## Fire Marshal Division

**Re: Cape Fear Conference HQ  
25 Beaver Rd.  
Erwin, NC 28339**

**Application Number BCOM1912-0008**

ANSUL MANUAL #:	418087-12	NOTES: AS BUILT
DRAWING #:	1 OF 1	
SCALE:	NTS	DATE:
DRAWN BY:	JCA	11/20/2020

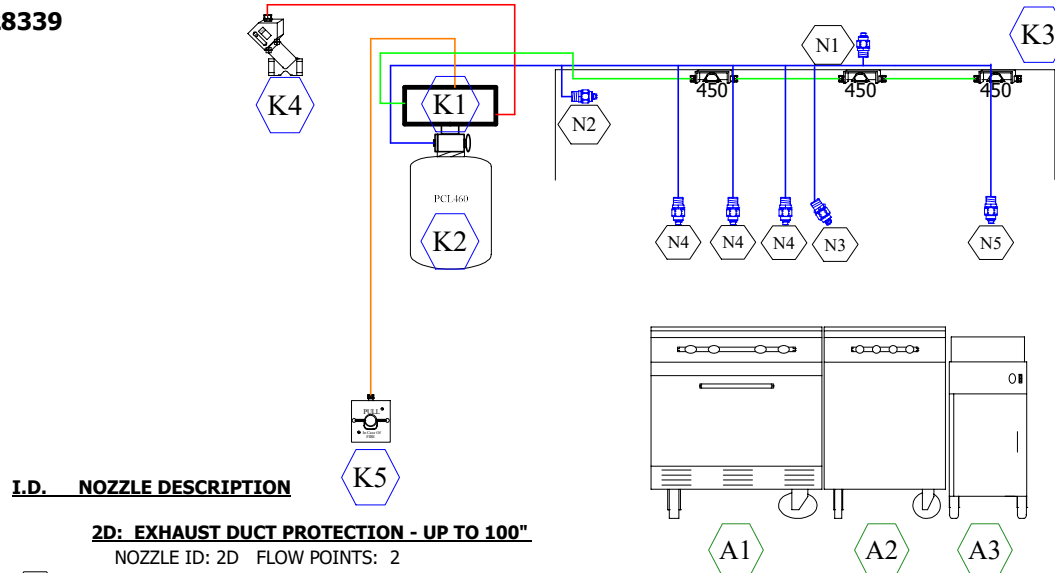
- **Commercial cooking equipment.**
  - Portable fire extinguishers shall be provided within a 30-foot (9144 mm) travel distance of commercial-type cooking equipment. Cooking equipment involving vegetable or animal oils and fats shall be protected by a Class K rated portable extinguisher.
- **Acceptance Test**
  - An acceptance test will be conducted by the Fire Marshal's office once system has been installed and pre-tested.
  - Installation shall be per architectural and system submittals and compliant with NFPA-17A.
- **Manual system operation**
  - A manual actuation device shall be located at or near a means of egress from the cooking area, a minimum of 10 feet (3048 mm) and a maximum

of 20 feet (6096 mm) from the kitchen exhaust system. The manual actuation device shall be located a minimum of 4.5 feet (1372 mm) and a maximum of 5 feet (1524 mm) above the floor. The manual actuation shall require a maximum force of 40 pounds (178 N) and a maximum movement of 14 inches (356 mm) to actuate the fire suppression system.

- The actuation of the fire suppression system shall automatically shut down the fuel or electrical power supply to equipment under the hood system. The fuel and electrical supply reset shall be manual.
